6th September 2016

Re: treeIQ Response to Submissions for SSD 7054 – F07 Lees 1

Please see below our response in relation the various tree management issues raised by Department of Planning & Environment, Office of the Government Architect, City of Sydney and NSW Heritage Council regarding the proposed Lees project. Our response summarizes how the proposal has been designed in accordance with *Australian Standard 4970 Protection of Trees on Development Sites (2009)* and *Australian Standard 4373 Pruning of Amenity Trees (2007)*. With the use of best practice tree management during the development period, the proposed works should not significantly impact the health or Useful Life Expectancy of the trees to be retained.

## South Elevation

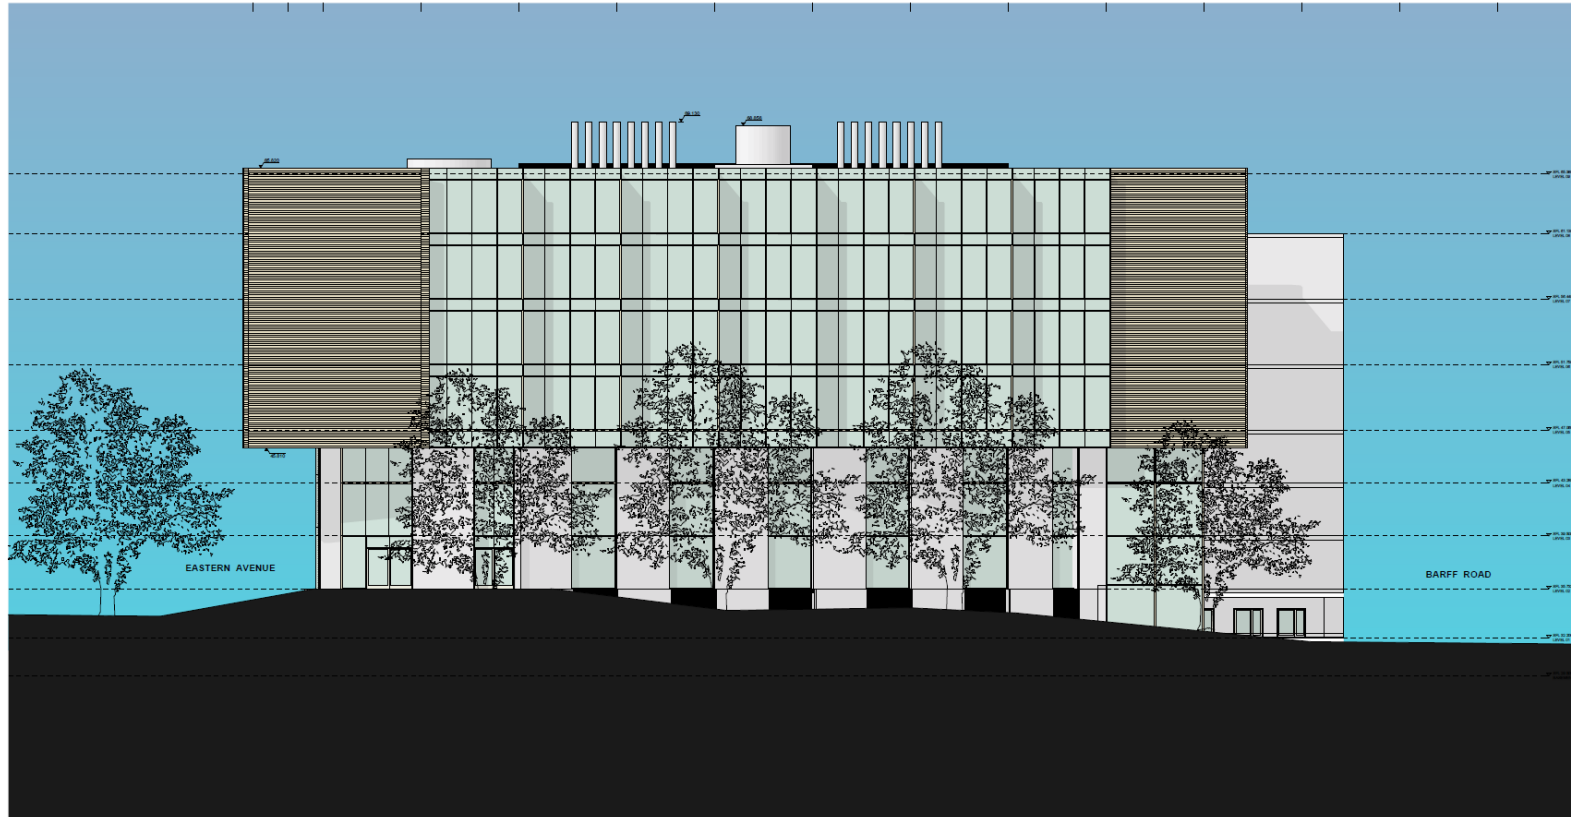
The Heritage Council recommends that the University of Sydney submit revised architectural design drawings for assessment. The southern façade (levels 1-4) and overhanging stepped façade (levels 5- 8) should be setback a further 3 metres from these Morten Bay Figs; to ensure that the LEES1 Building development does not encroach into the canopy and Tree Protection Zone of the four (4) Moreton Bay Figs along City Road, numbered T970, T971, T972 and T973 in the Arborist Report.

The Pruning Specifications was based on a ground level assessment and has identified all larger diameter branches that would potentially conflict with the proposed building. Additional surveying has been undertaken and plans have been prepared to confirm building clearances. As per Section 3.6.7 of the Arboricultural Impact Assessment (Rev D, 11.04.16), any additional pruning in sections of the trees' upper crowns to accommodate sections of the proposed building projection will be limited to branches no greater than 50mm diameter. This pruning work should represent terminal growth only which could be either pruned with hand tools from hoardings/scaffolding or temporarily pushed back.

The proposed building has been designed so that Level 5 projects forward in a stepped fashion towards the trees by up to 2.5m. The trees have an asymmetric crown form resulting from high levels of shading from the adjacent trees and the existing building to the north. Although the proposed building is located in closer proximity to the trees (than the current building), the level of shading will not be significantly altered. *Ficus macrophylla* are a species tolerant of shading and the shade cast by the proposed building is not anticipated to significantly impact the trees.

NOTE: REFER TO AIA PREPARED BY TREE IQ

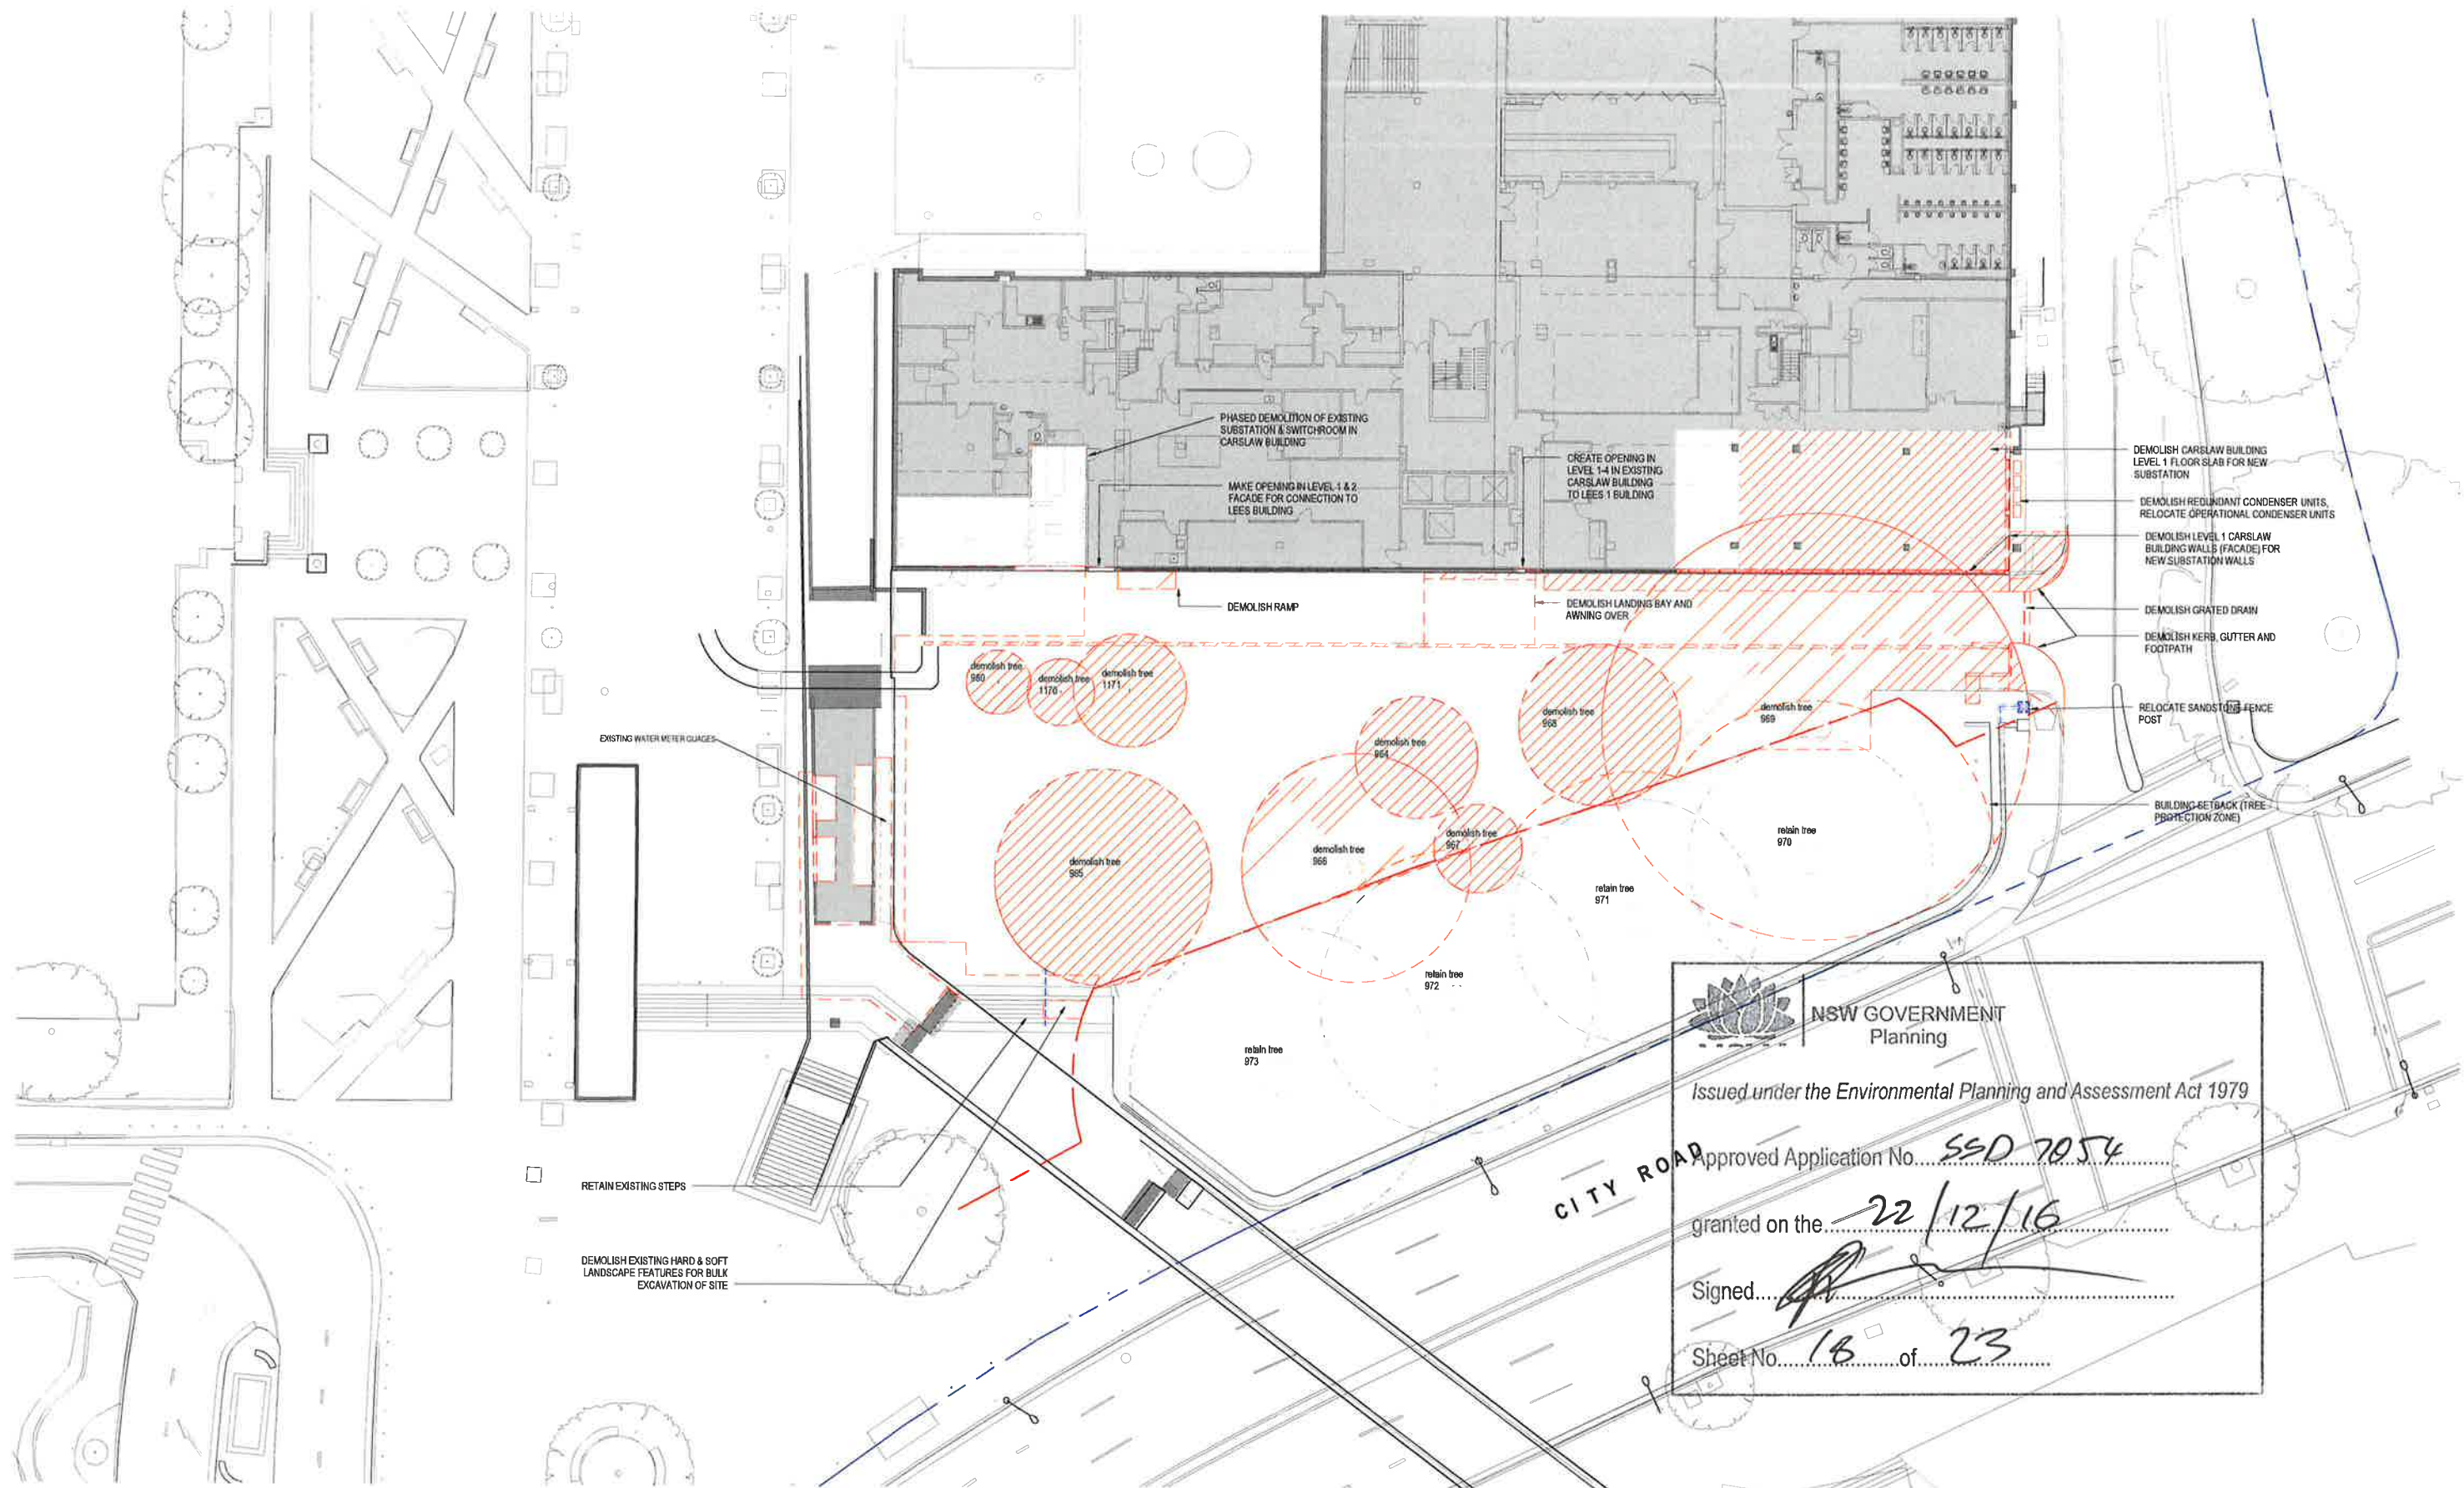
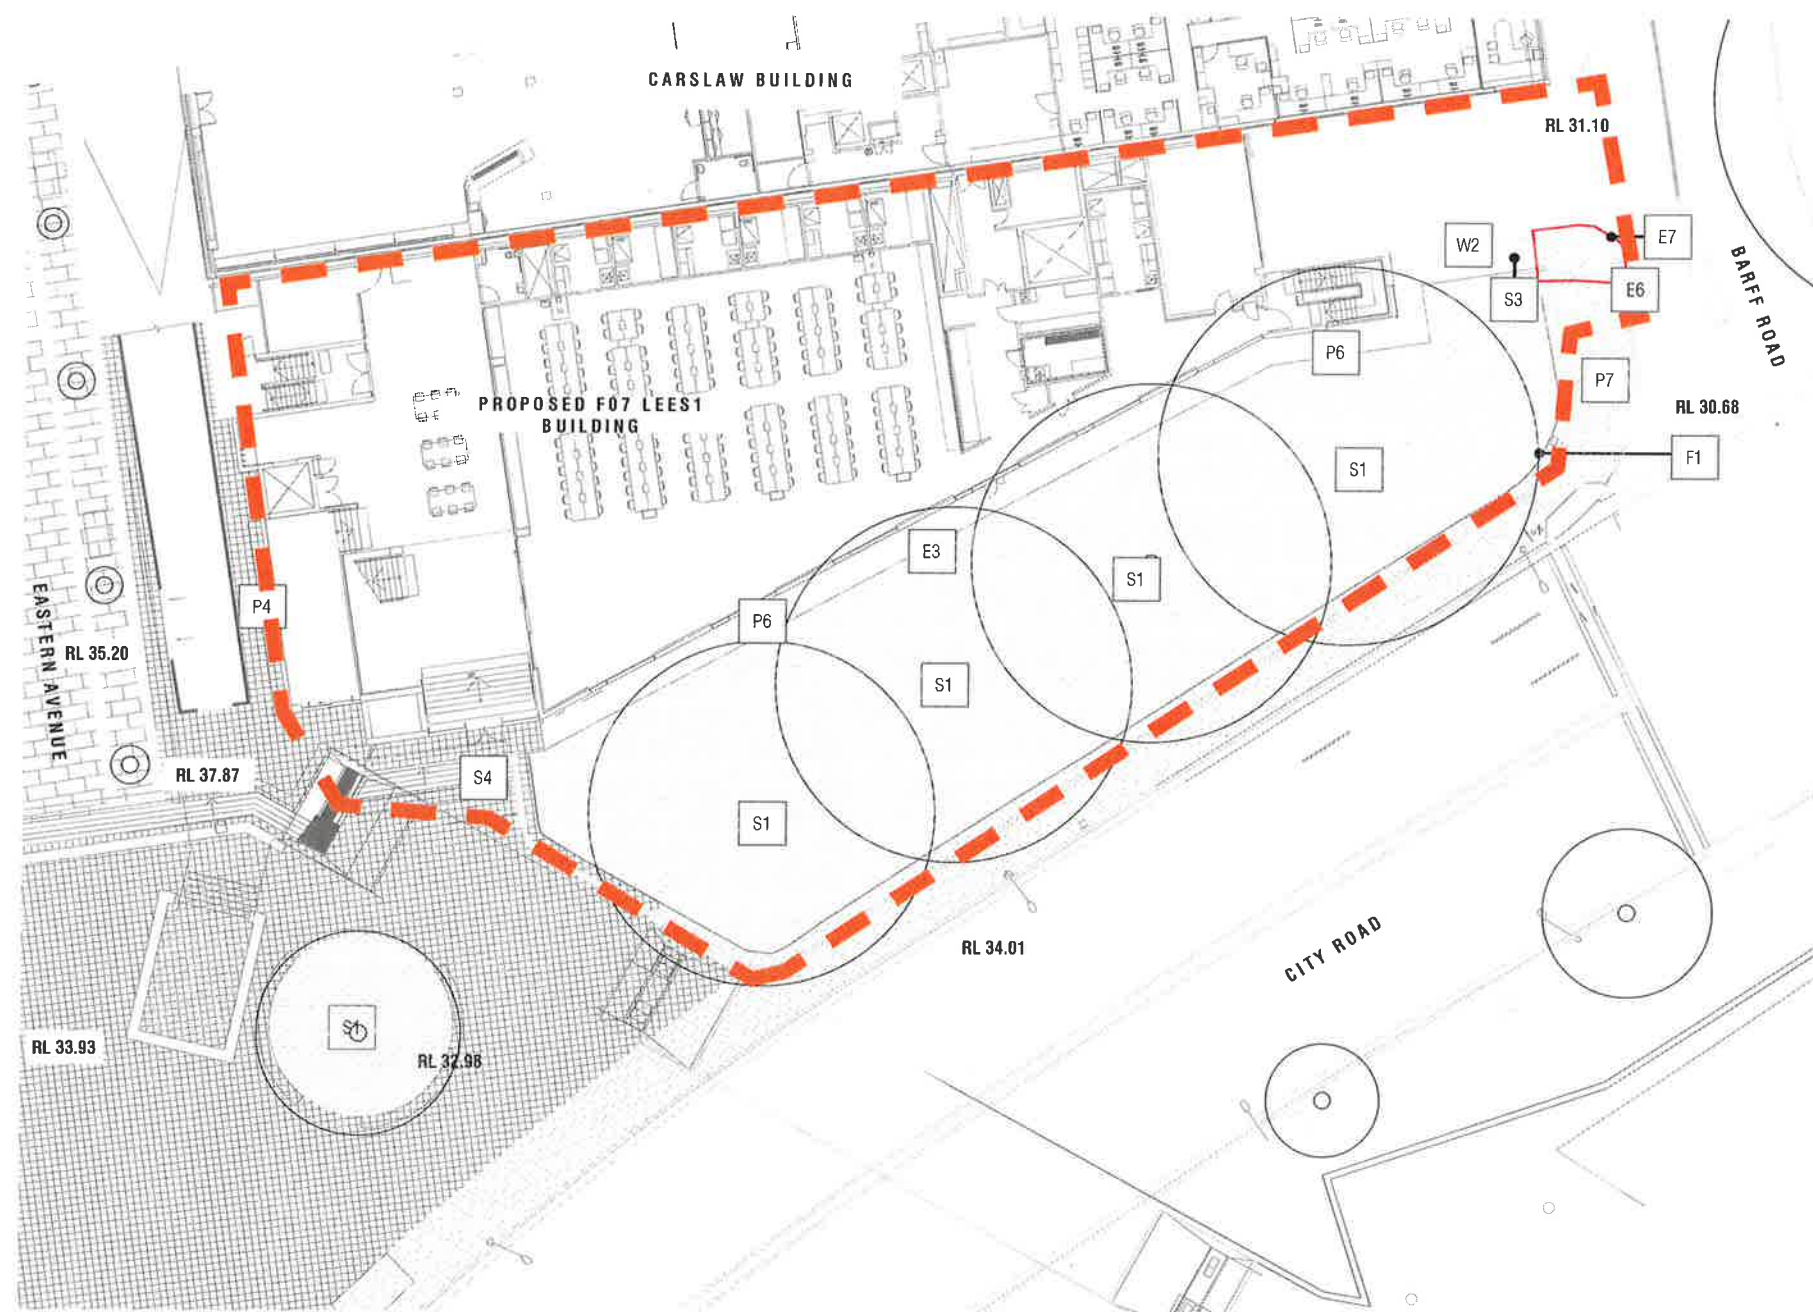
2 - The amount of pruning [of the Moreton Bay Figs on City Road] anticipated in the report does not reflect the distance of the proposed building or allow for scaffolding/hoarding, building clearance and potential construction access associated with construction. Further, the report does not consider any future allowance for tree canopy growth which will inevitably occur each year. Following a recent site inspection, it is considered that major pruning of T971, T972 and T973 will be required to facilitate construction. It is expected that the current design and scaffolding will require the removal of large primary branches (200 – 400mm diameter).

Concern is also raised with regard to works within the Tree Protection Zone (TPZ) of the Moreton Bay Fig trees.

As part of the design development stage, TreeiQ determined the maximum amount of pruning acceptable based on an individual assessment of the trees' crown form and the constraints of *Australian Standard 4373 Pruning of Amenity Trees (2007)*. The proposed building was sited based on the trees' crown form, following these pruning works.

The Pruning Specification was based on a ground level assessment and has identified all larger diameter branches that would potentially conflict with the proposed building. Additional surveying has been undertaken and plans have been prepared to confirm building clearances. As per Section 3.6.7 of the Arboricultural Impact Assessment (Rev D, 11.04.16), any additional pruning in sections of the trees' upper crowns to accommodate sections of the proposed building projection will be limited to branches no greater than 50mm diameter. This pruning work should represent terminal growth only which could be either pruned with hand tools from hoardings/scaffolding or temporarily pushed back.

The proposed building has been designed so that Level 5 projects forward in a stepped fashion towards the trees by up to 2.5m. The trees have an asymmetric crown form resulting from high levels of shading from the adjacent trees and the existing building to the north. Although the proposed building is located in closer proximity to the trees (than the current building), the level of shading will not be significantly altered. *Ficus macrophylla* are a species tolerant of shading and the shade cast by the proposed building is not anticipated to significantly impact the trees.
